Application for Planning Permission for Works or Extension to a Dwelling

Development: Demolition of single garage and erection of a single storey annexe build
Location: 4 Beechlands Close East Preston BN16 1JT

I regret that I am unable to accept your documents as a valid application until the following item(s) have been received or resolved :-

Revision:	A	Jan 26	Dimensions from boundary added
address	4 Beechlands Close, East Preston, West Sussex, BN16 1JT		
project	Erection of single storey annex building		
title	Proposed Block Plan		
scale	1:500 on A4	date	November 2025
		dwg no.	2025.473a.04
		revision	A

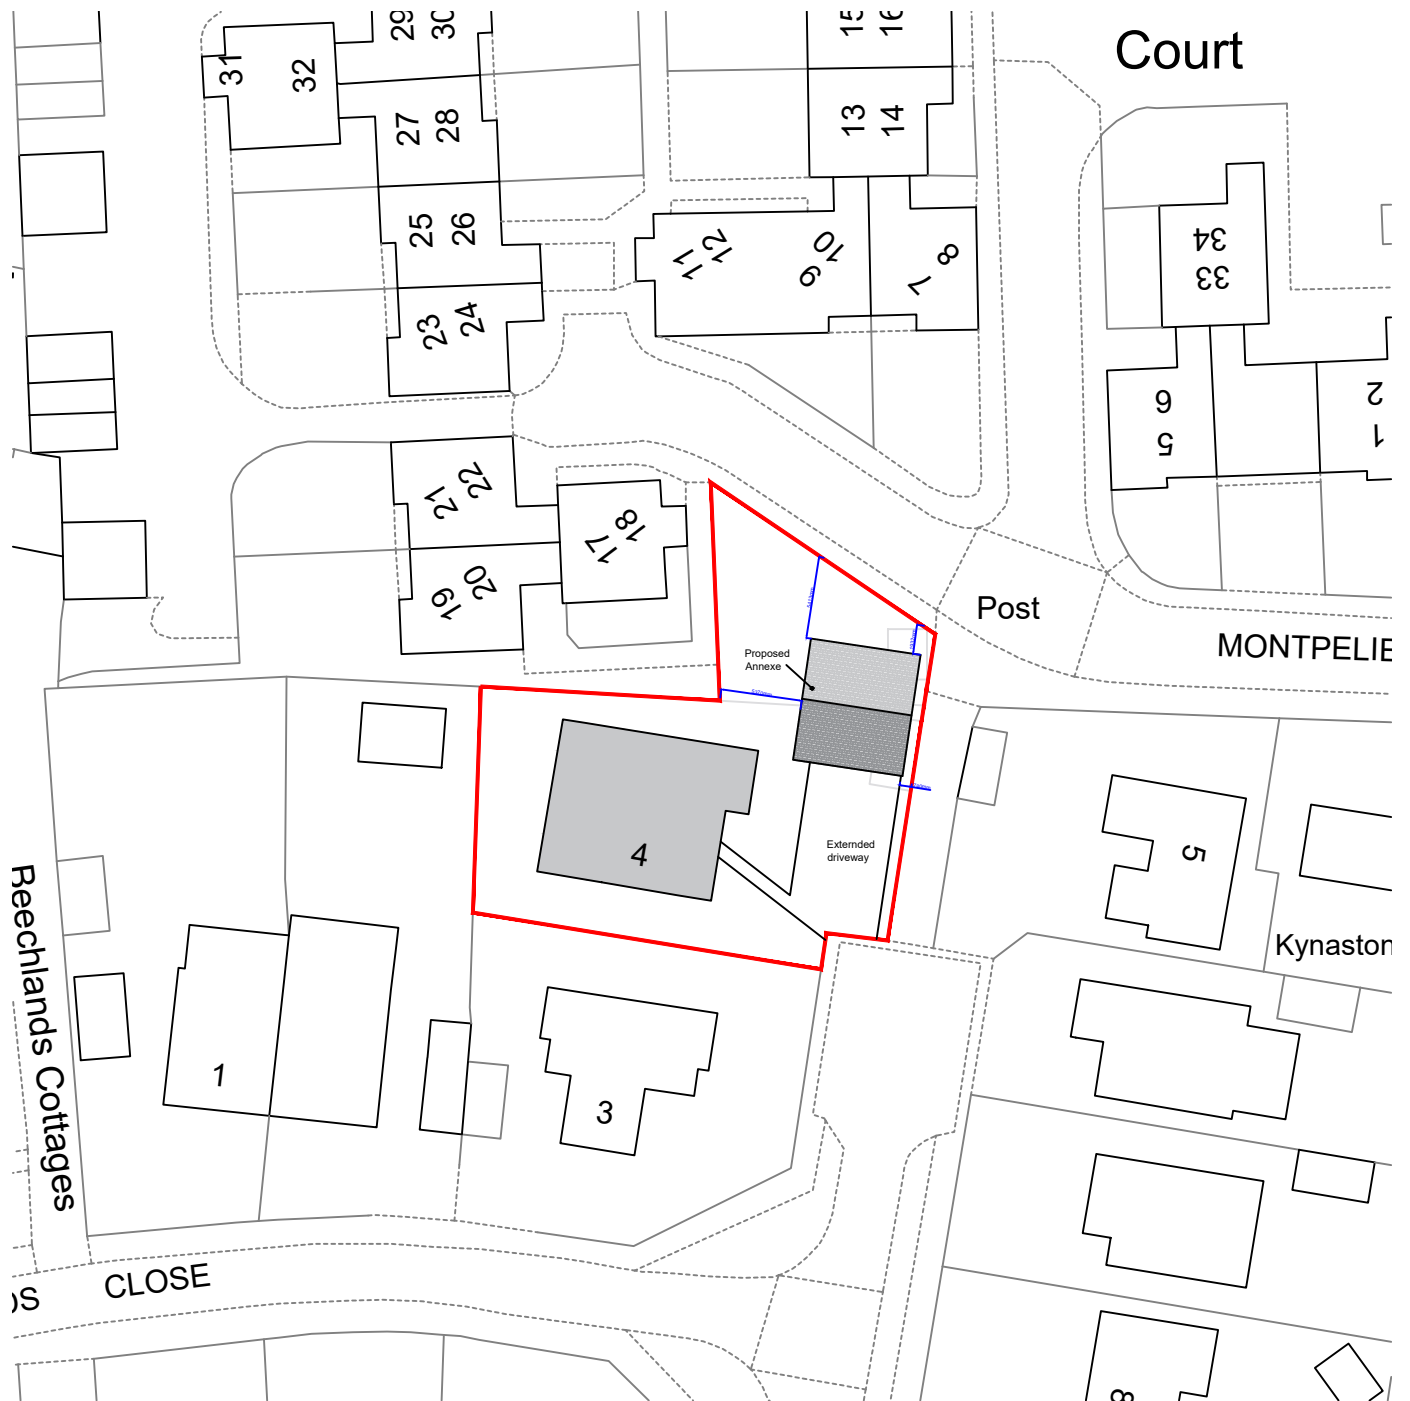
Block Plan

You are required to have dimensions from the proposed annexe to all site boundaries. Please amend.
